From: David O'Connell
To: [Michelle Niles](#)
Subject: RE: Notice of Modification Request - Casuarina Town Centre Project Approval (MP 06_0258 MOD 12)
Date: Thursday, 11 October 2018 2:43:30 PM
Attachments: [image004.png](#)

Following on from the below, Council staff have reviewed the Casuarina Town centre MOD 12 application and have provided the below comment for consideration/clarification;

The proposed Mod appears to relate to car park lot (36) located on the eastern side of Casuarina Way (area of 928m²), which was amalgamated by mistake. The applicant is seeking consent to re-instate the lot as a separate lot.

PROPOSED SUBDIVISION PLAN

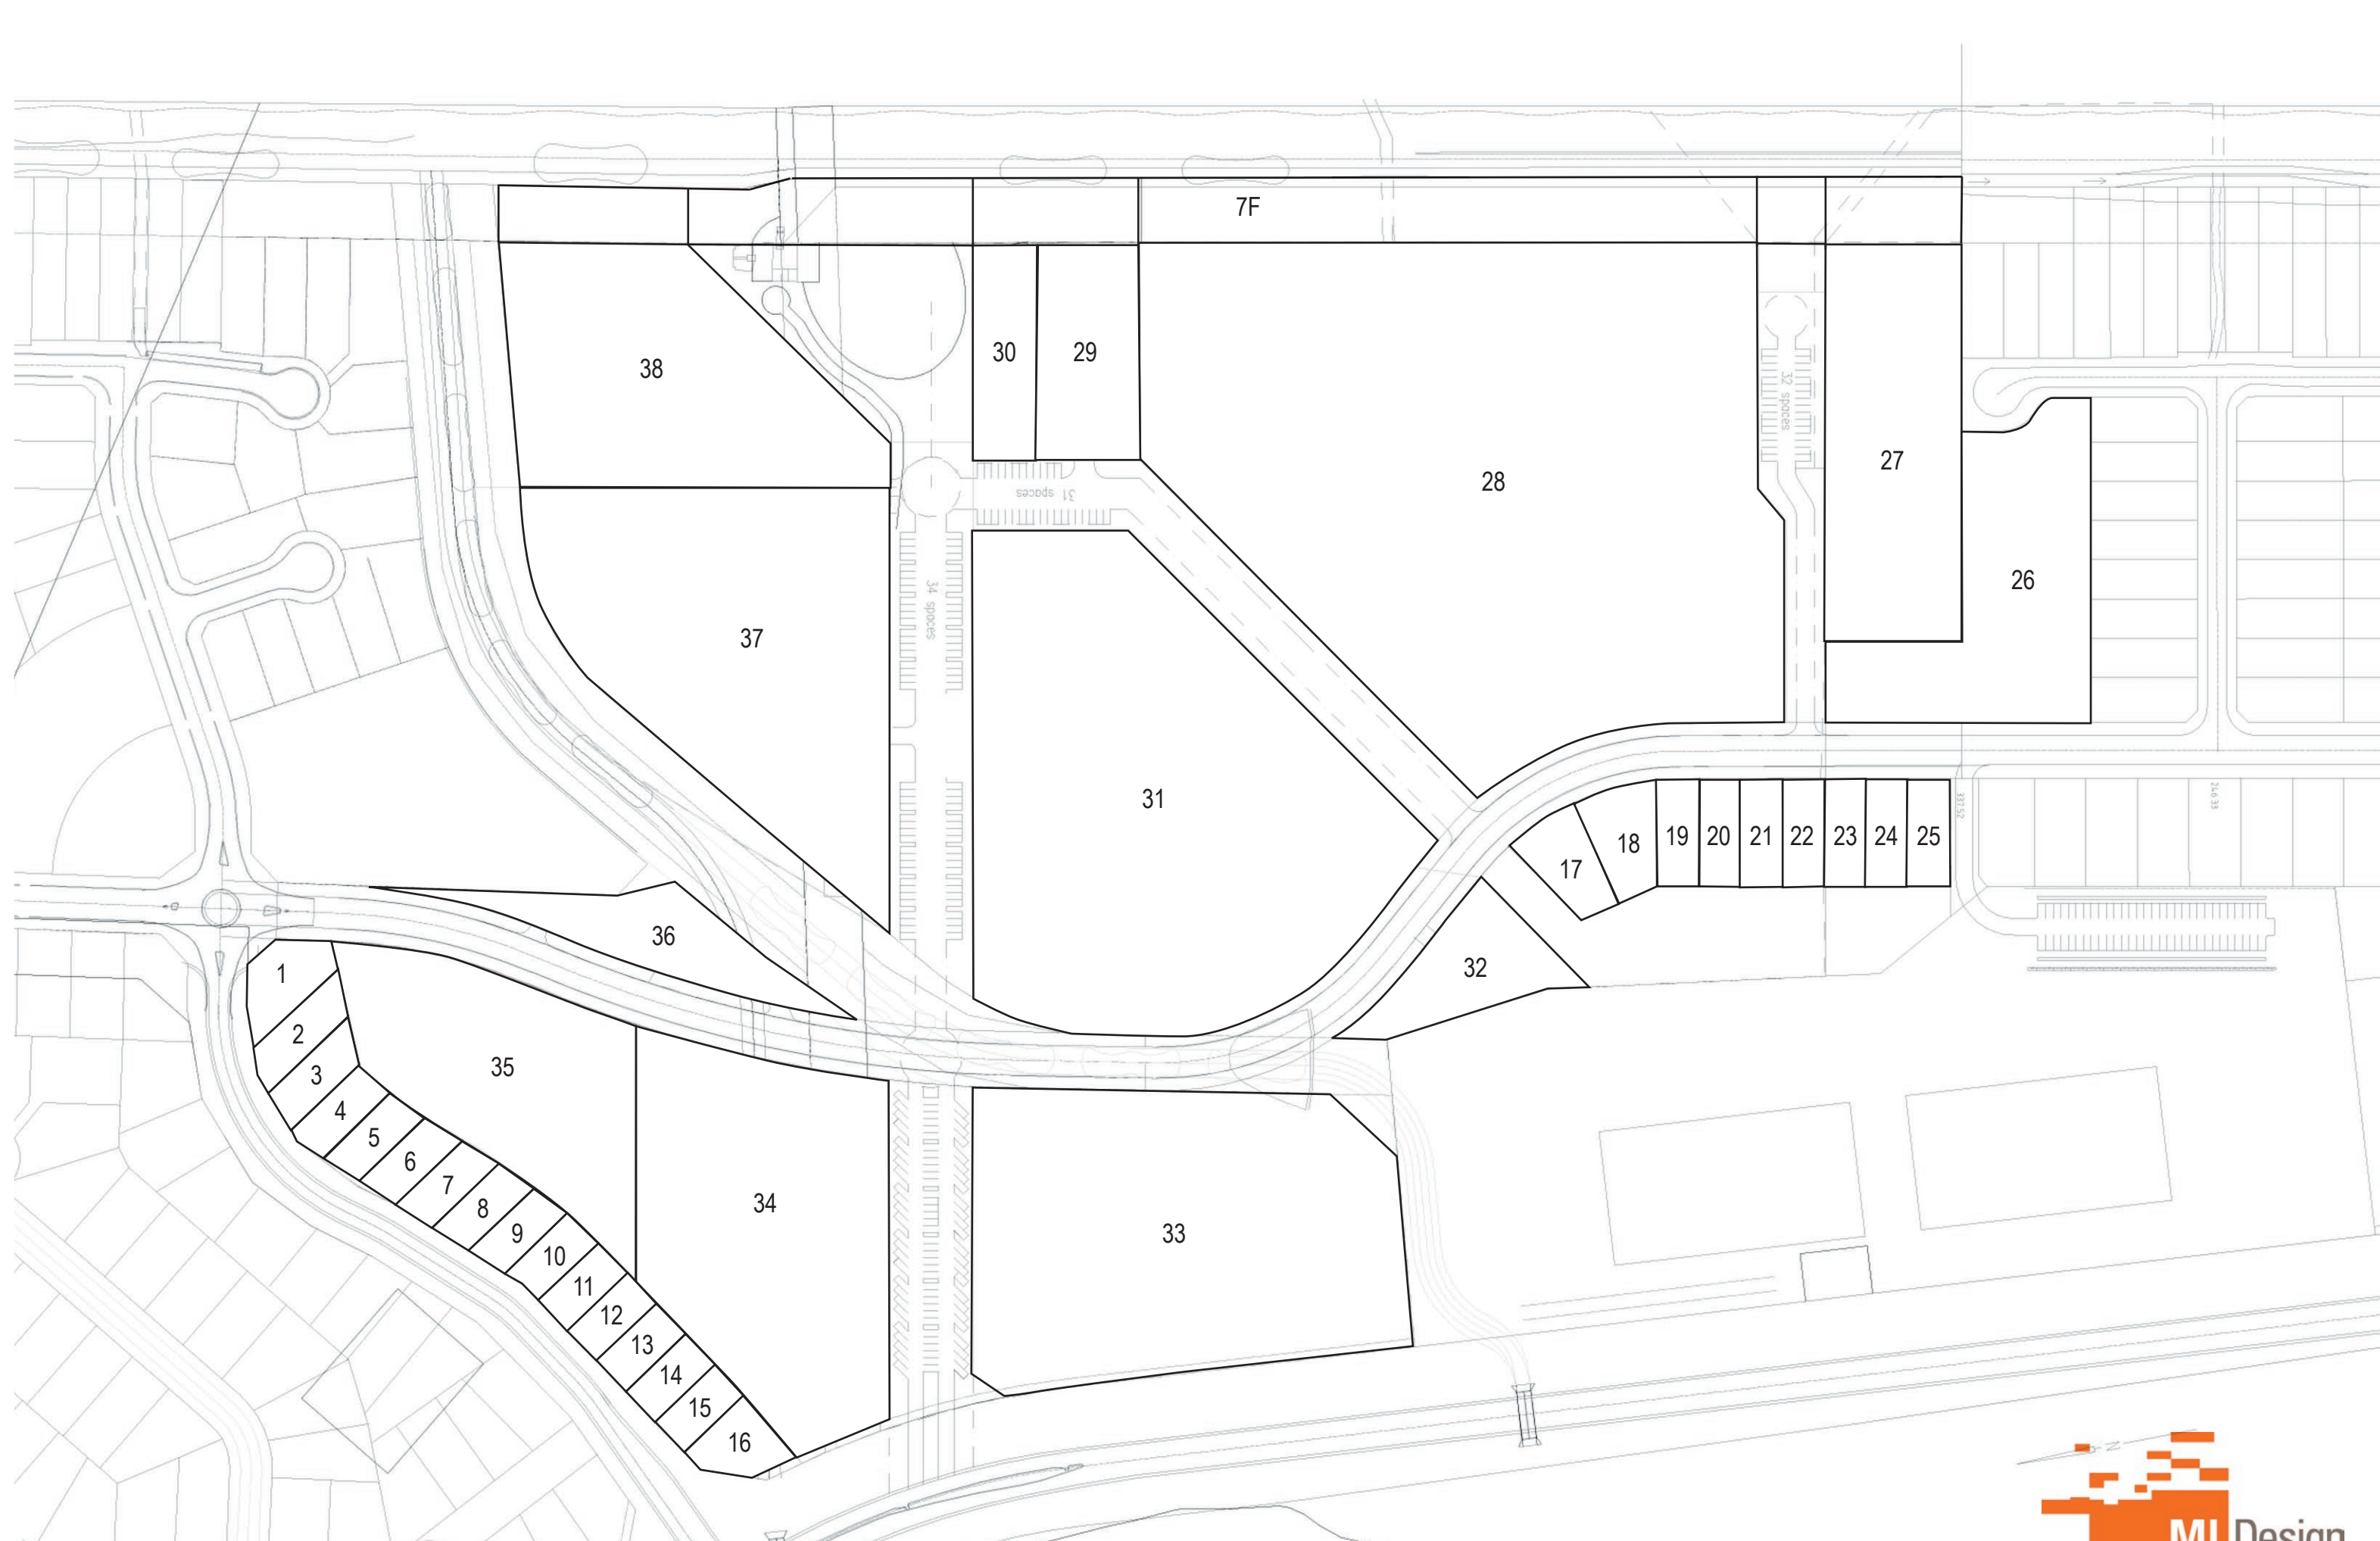
- The submitted application indicates that the original approval and overall intention of the development was for the car park lot to be a separate torrens title allotment, with the Appendix A Subdivision Plan (dated 10/10/2006) submitted in support of this. Clarification is sought as to whether this plan was ever approved in support of the applicant's assertion. A search of records by Council staff does not indicate that this plan was ever approved by the Department of Planning and was instead superseded by an alternate layout through the 'Response to Submissions' assessment of the original application.

1. The applicant has referenced a drawing in their appendix A - "Proposed Subdivision Plan dated 10/10/2006 by MLDesign" as an approved plan indicating that the car parking area was a separate lot to that of the medium density lot. All consent approvals do not indicate that this drawing was approved as part of the original consent. Clarification may be required from the applicant where this drawing was approved as part of the consent.
